THE SOD GUY - SALES LOT

SITE DEVELOPMENT PLANS
LOT 1, APPALOOSA HIGHWAY 24 SUBDIVISION

Site Plan_v1-redline.pdf Markup Summary

SHEET NO:	C-01
DATE:	01/11/19
PAGE NO:	1 OF 1

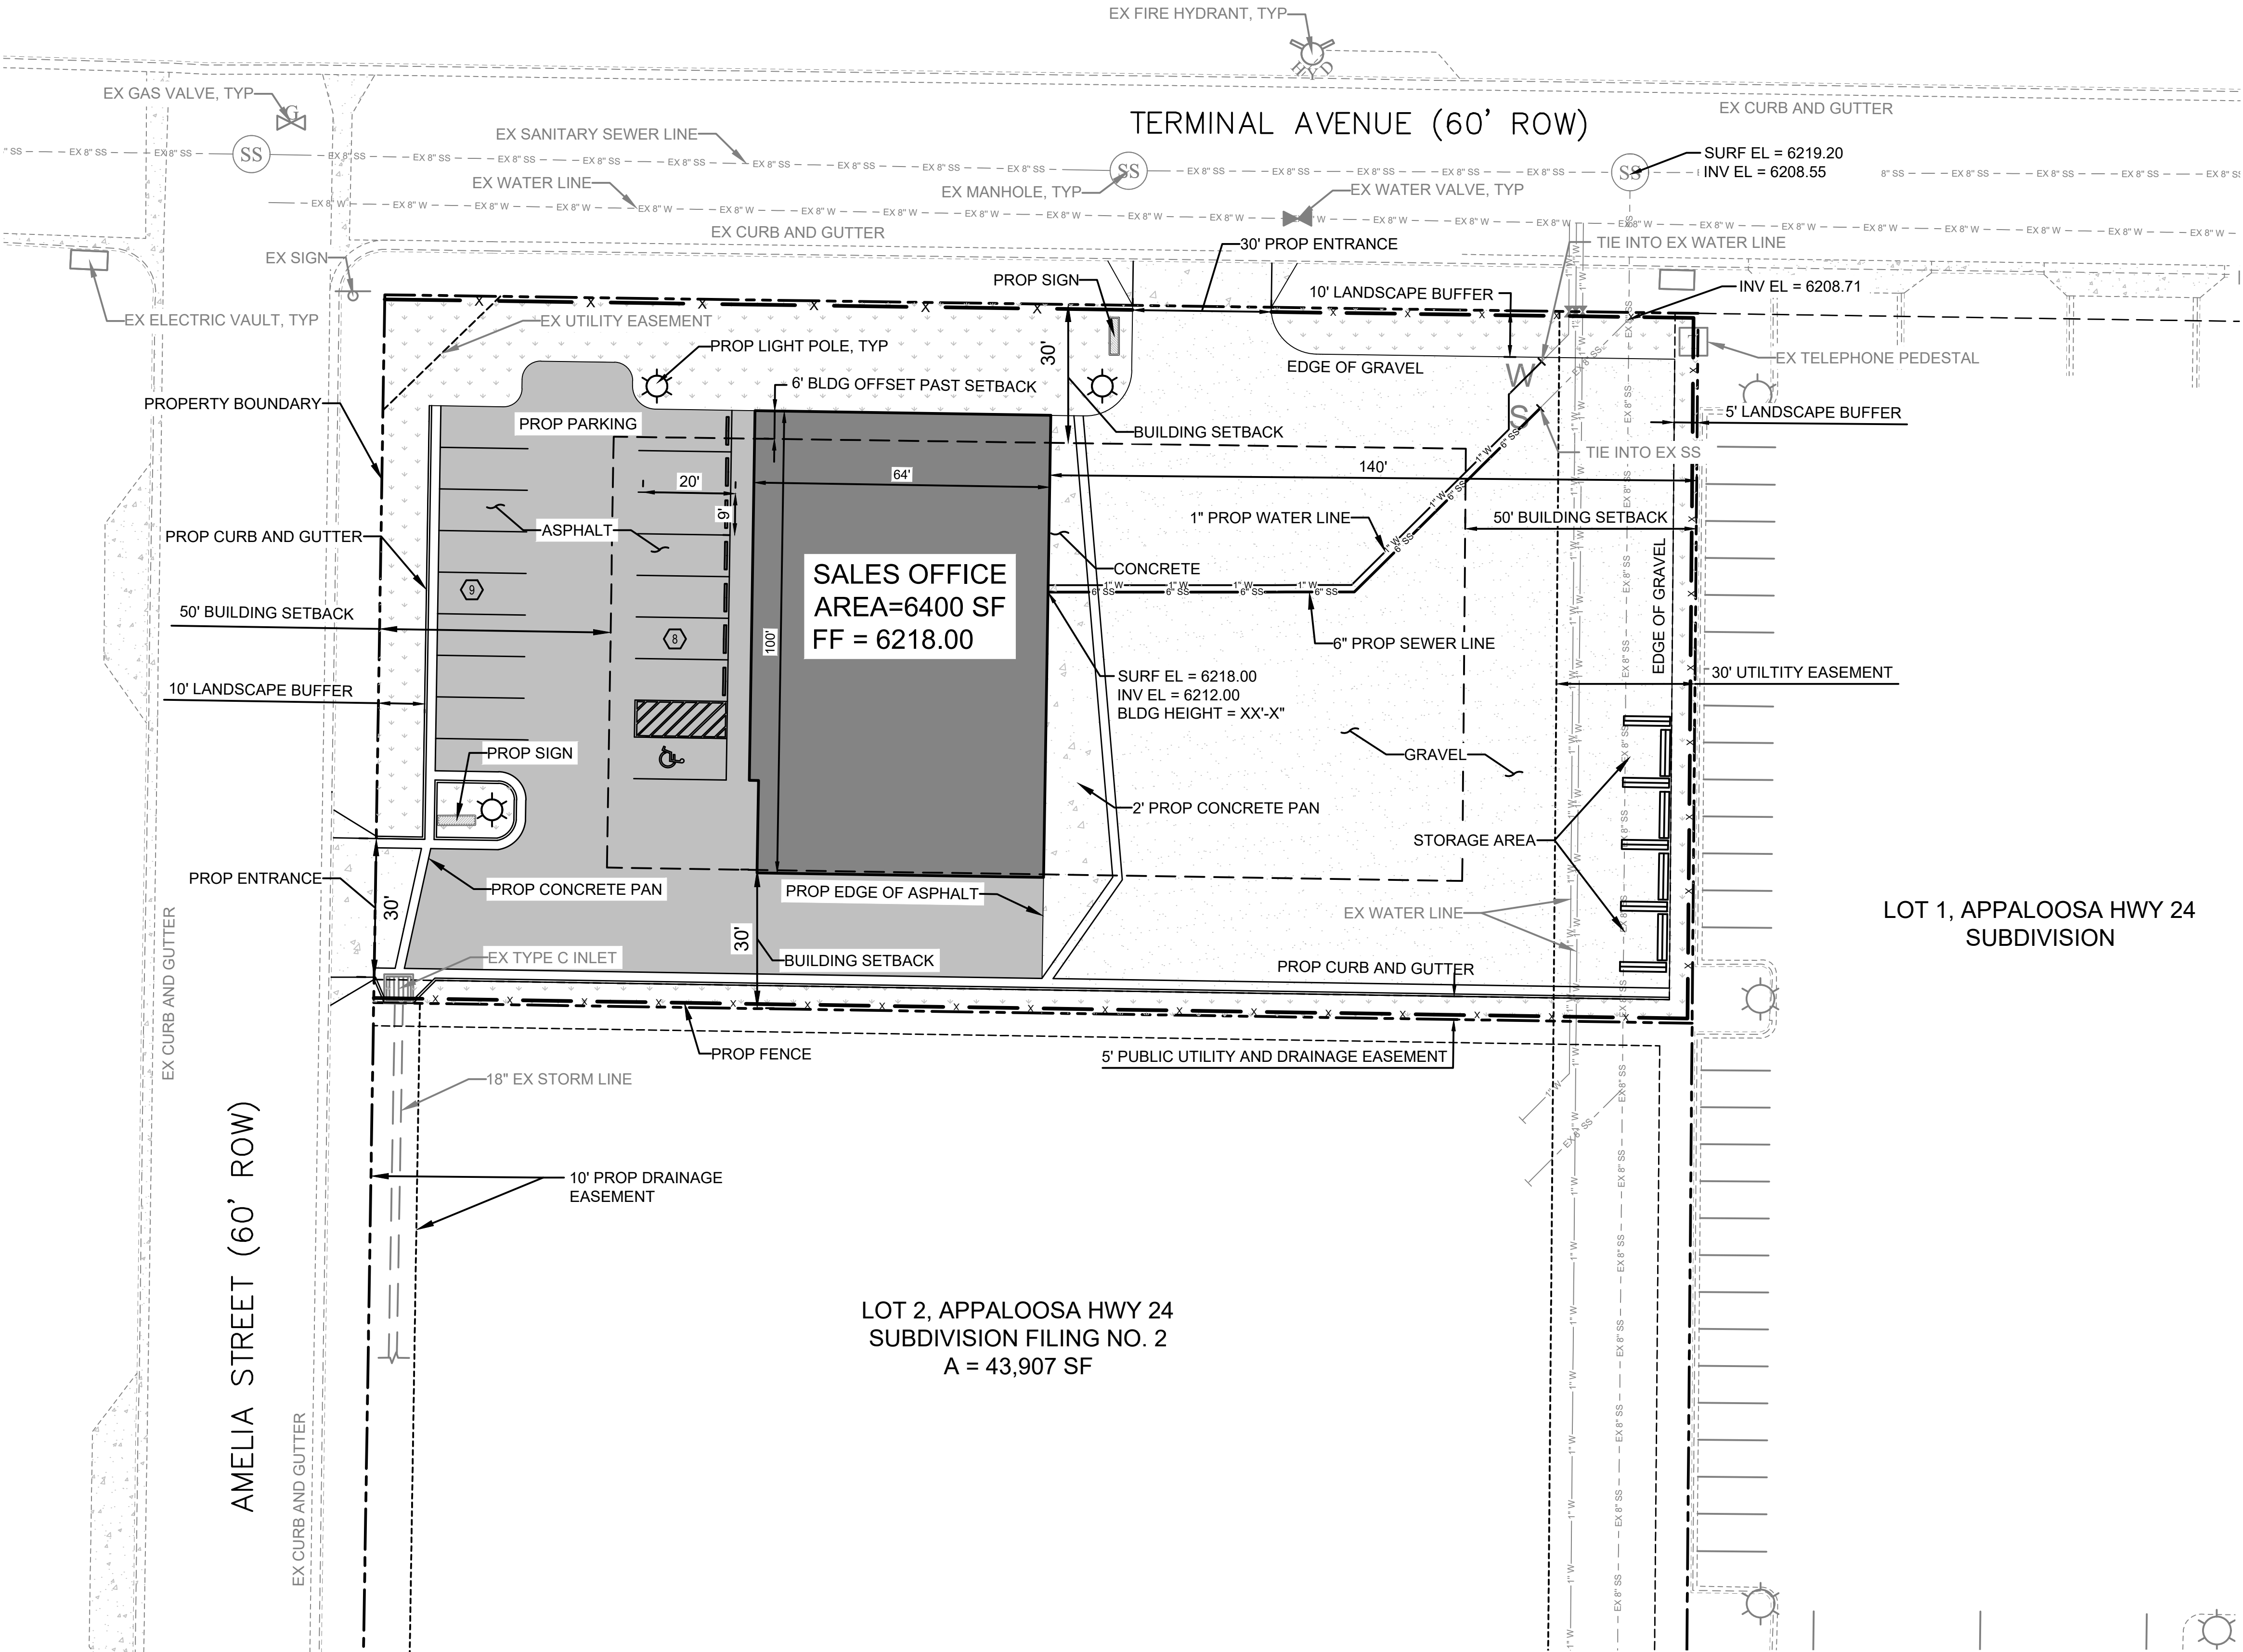
Based on the definition in the Land Development Code of Lot line, Front, the front yard setback of 50 feet would apply to all property lines that have an access to a road.

This would be a 50 foot front-yard setback.
